TOWN AND COUNTRY PLANNING ACT 1990 OUTLINE

Reference:	H13-1081-22	Date of Decision:	3rd January 2023
Applicant:	Mr J Hitcham 18 Roman Bank Moulton Seas End Spalding PE12 6LG		
Location:	Rear Of 18 Roman Bank Moulton Seas End Spalding		
Description:	Residential Development

Project	RESIDENTIAL DEVELOPMENT EAST OF I-18 & 200 BOWMAN PARK, MOLITION 35.45 BLD. SPALDING, LINC 5, FBI 2 BLD.		
Client	J. HITCHAM.		
Drawing	SITE & LOCATION PLANS.		
Job Ref.	4087-22.	Drawing No.	01.
Date	OCTOBER 2022.	Drawn	S.L.D.

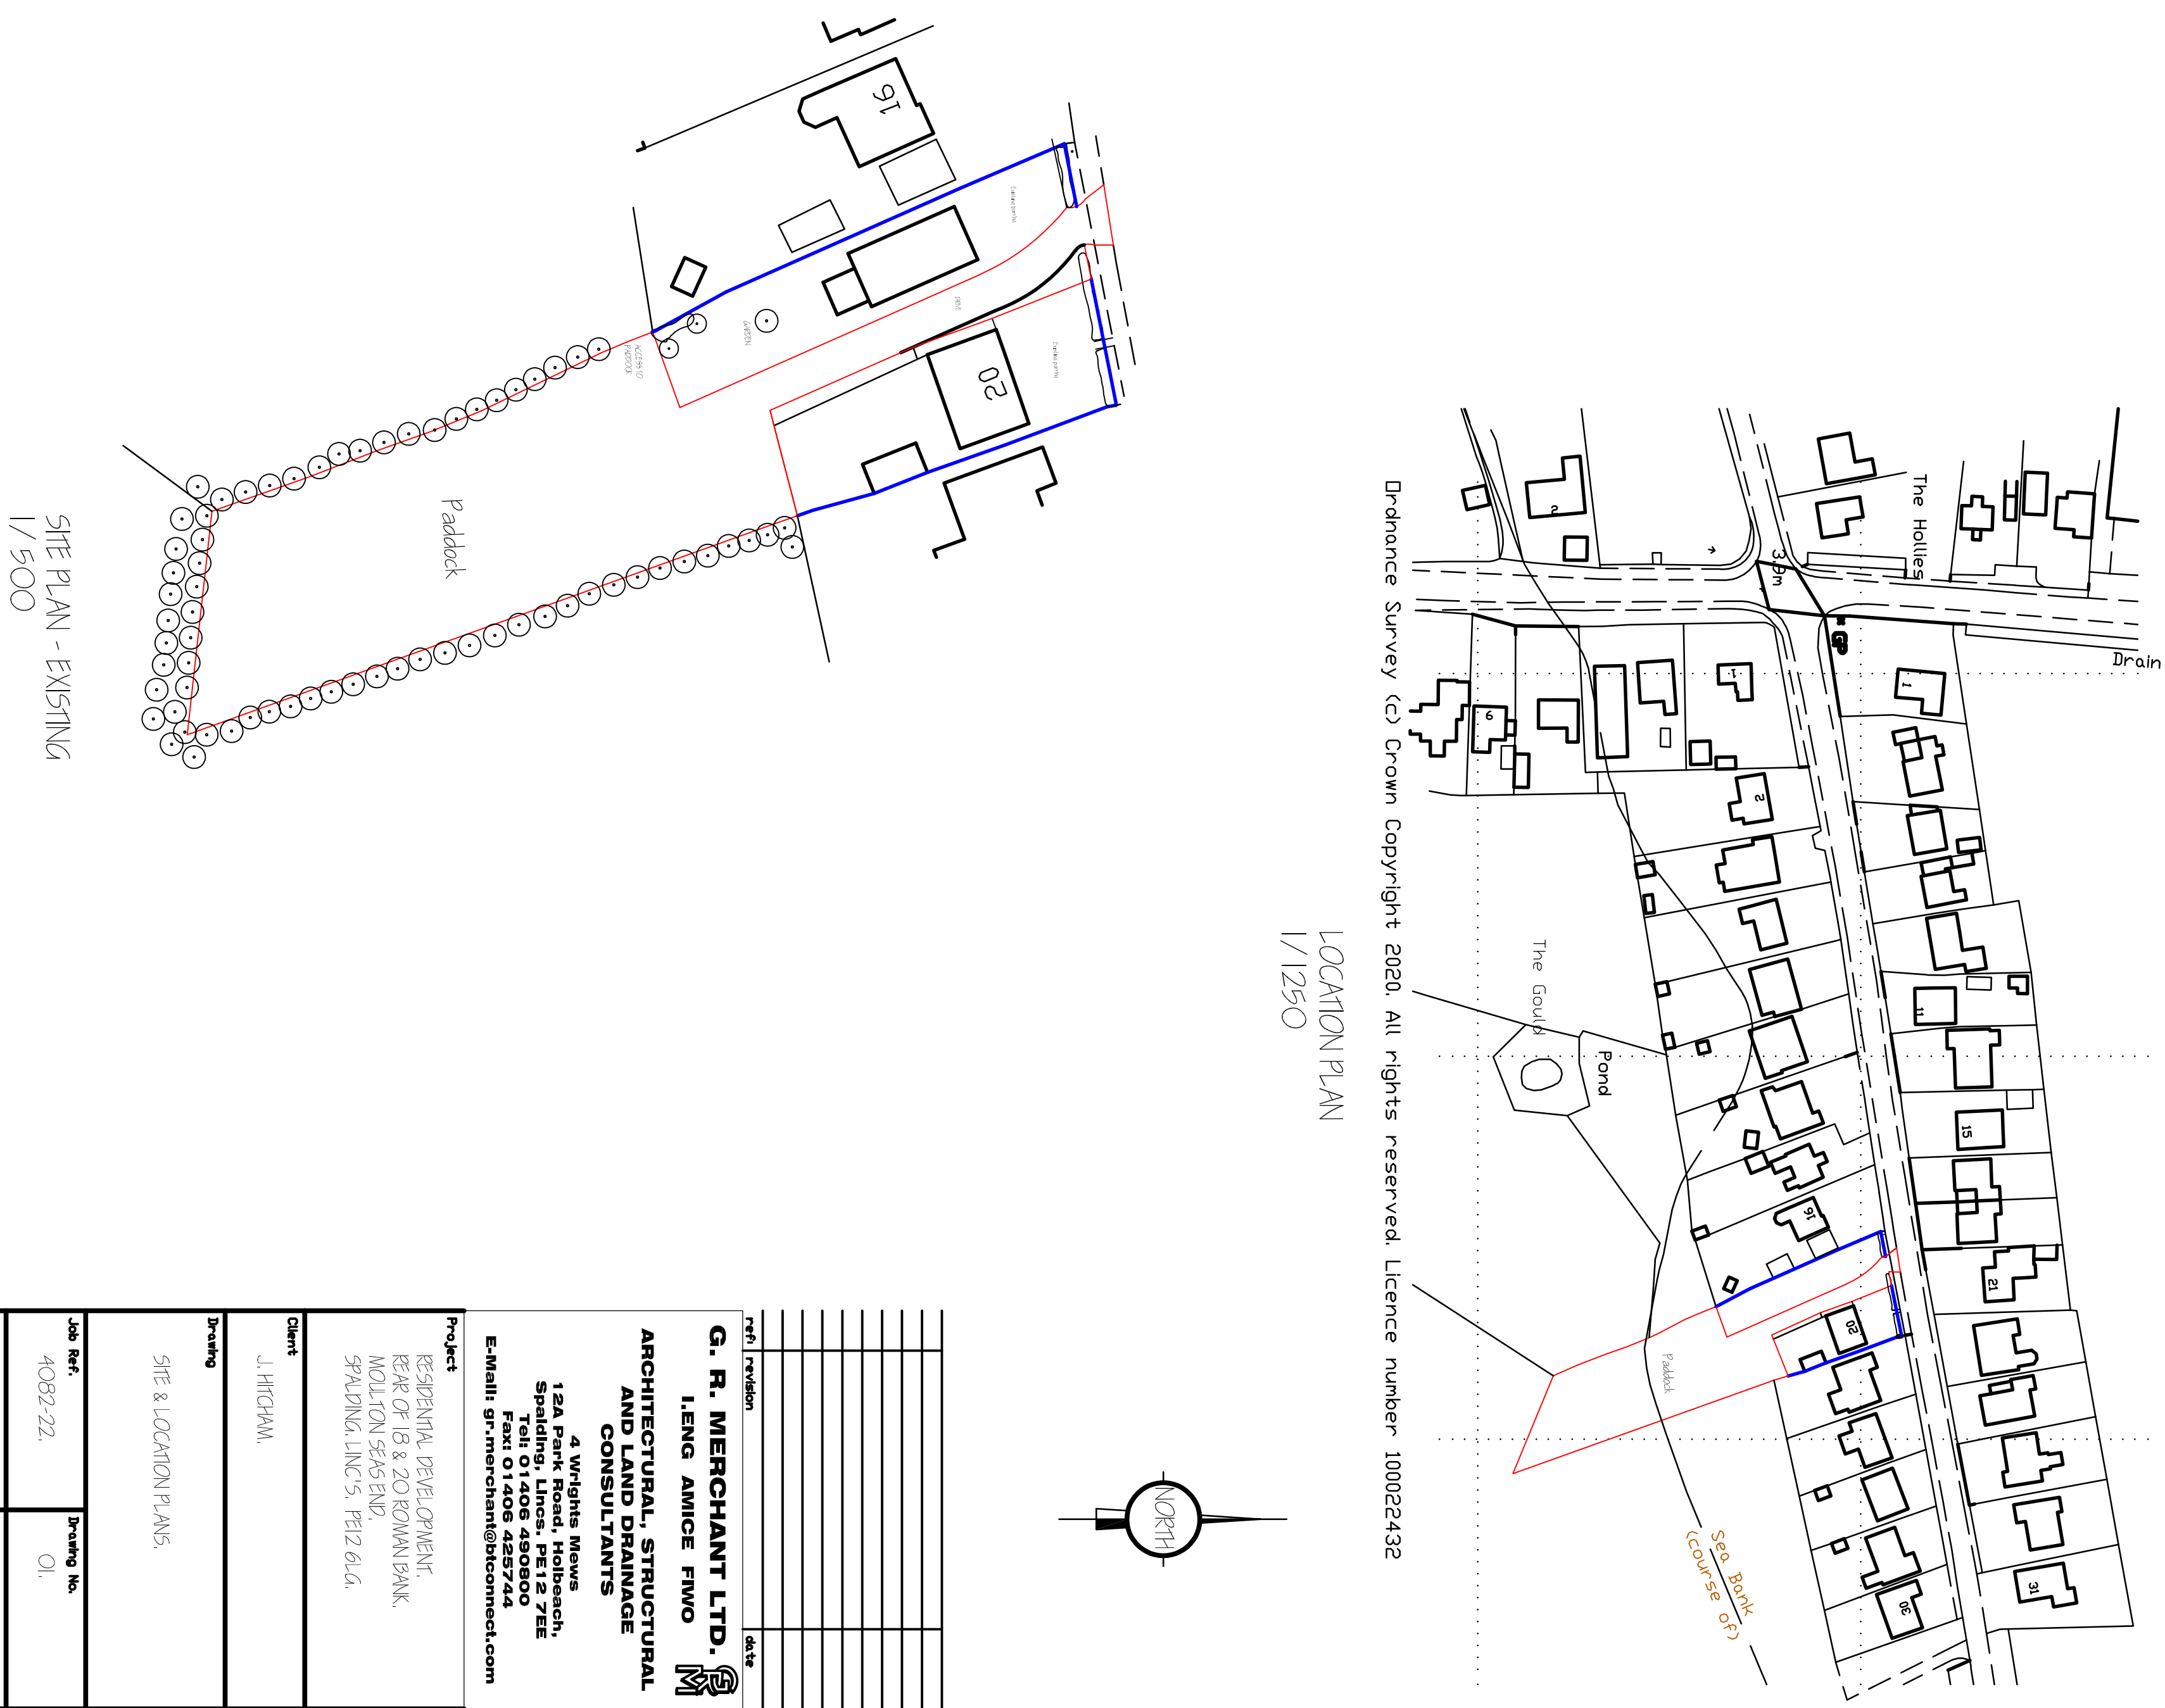
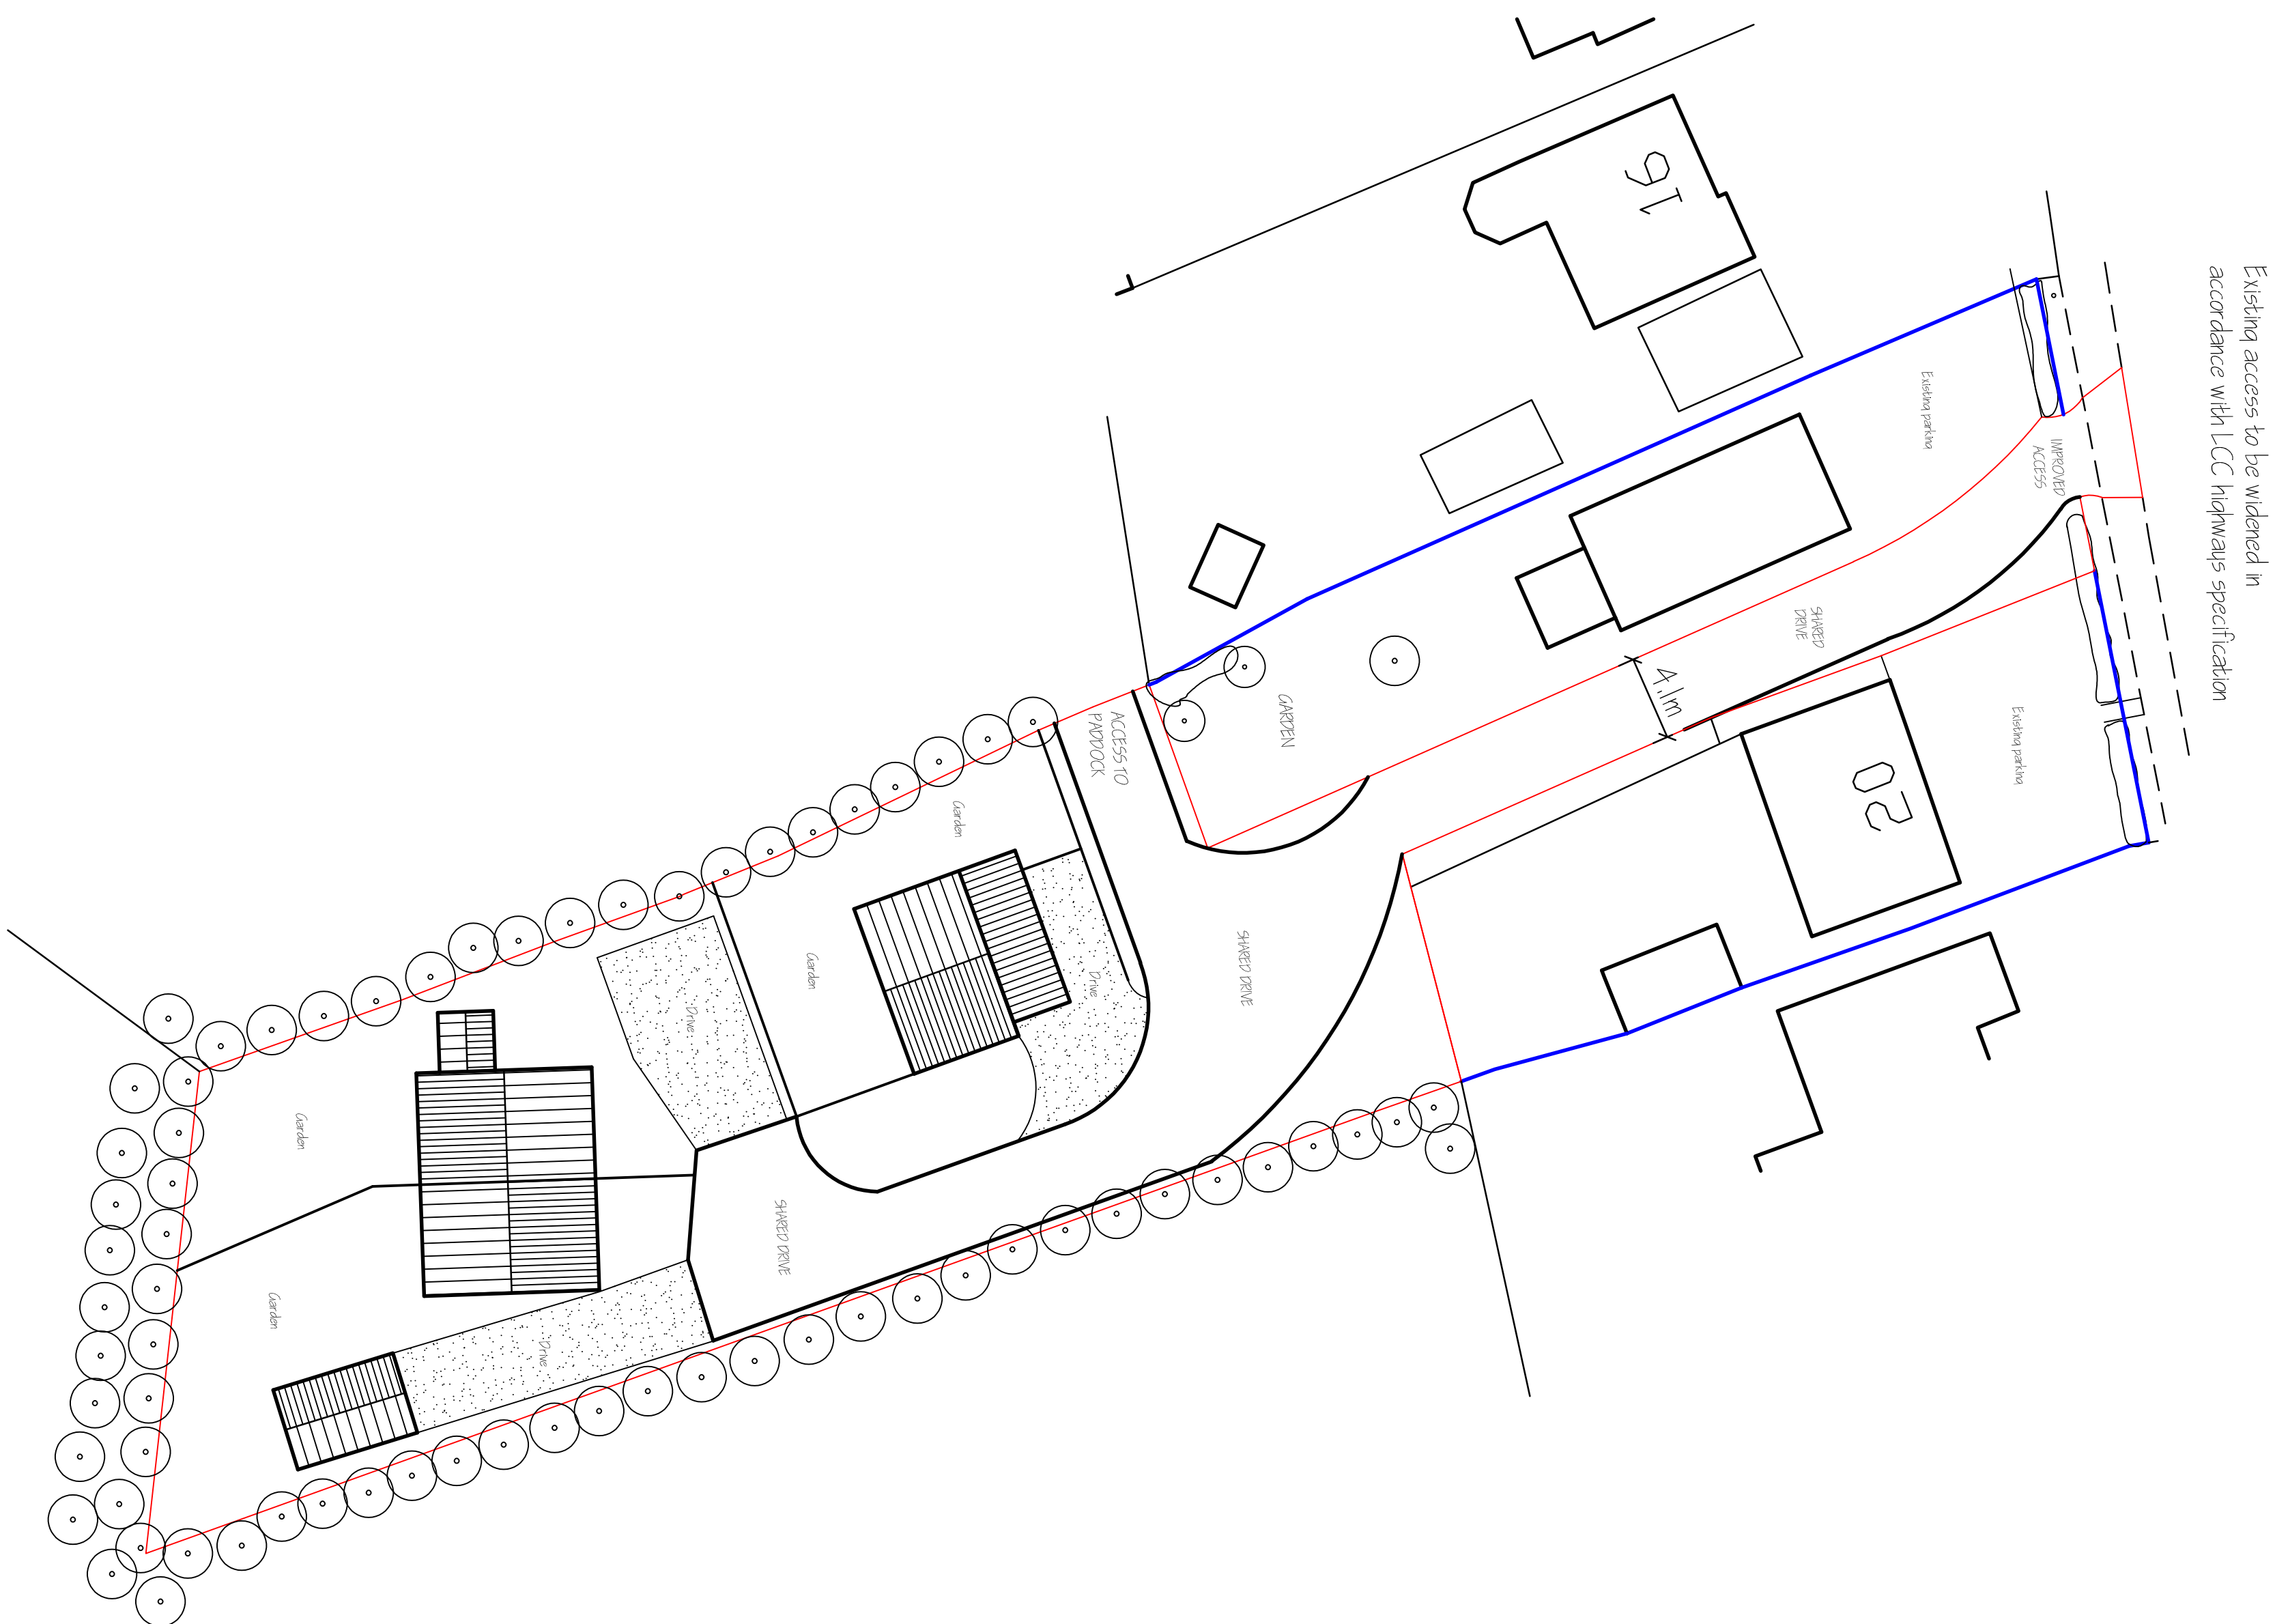
In addition, the site contributes to the character of the countryside. The proposed dwellings would not be keeping with the pattern of the residential frontage along the southern side of Roman Bank. The form of development would represent an encroachment on to the open field's adjacent further south. The proposal would not be

integrated sensitively with the character and appearance of the surrounding area contrary to Policies 2 and 3 of the South East Lincolnshire Local Plan. It is considered that any benefits identified above would be outweighed by the environmental harm that the proposal would cause.

- 2 The length of the private drive and resulting carrying distances in order to deposit refuse/recycling sacks kerbside would be contrary to South Holland District Council's Private Drives - Waste Vehicle Collection Service - Guidance Note. This states that carrying distances should be less than 30m from the nearest point of the plot adjacent to the private drive to the collection point.
The part of the site in which dwellings would be located would be in excess of this distance. It is therefore contrary to Policy 3 of the South East Lincolnshire Local Plan (2019) in terms of ensuring appropriate design.
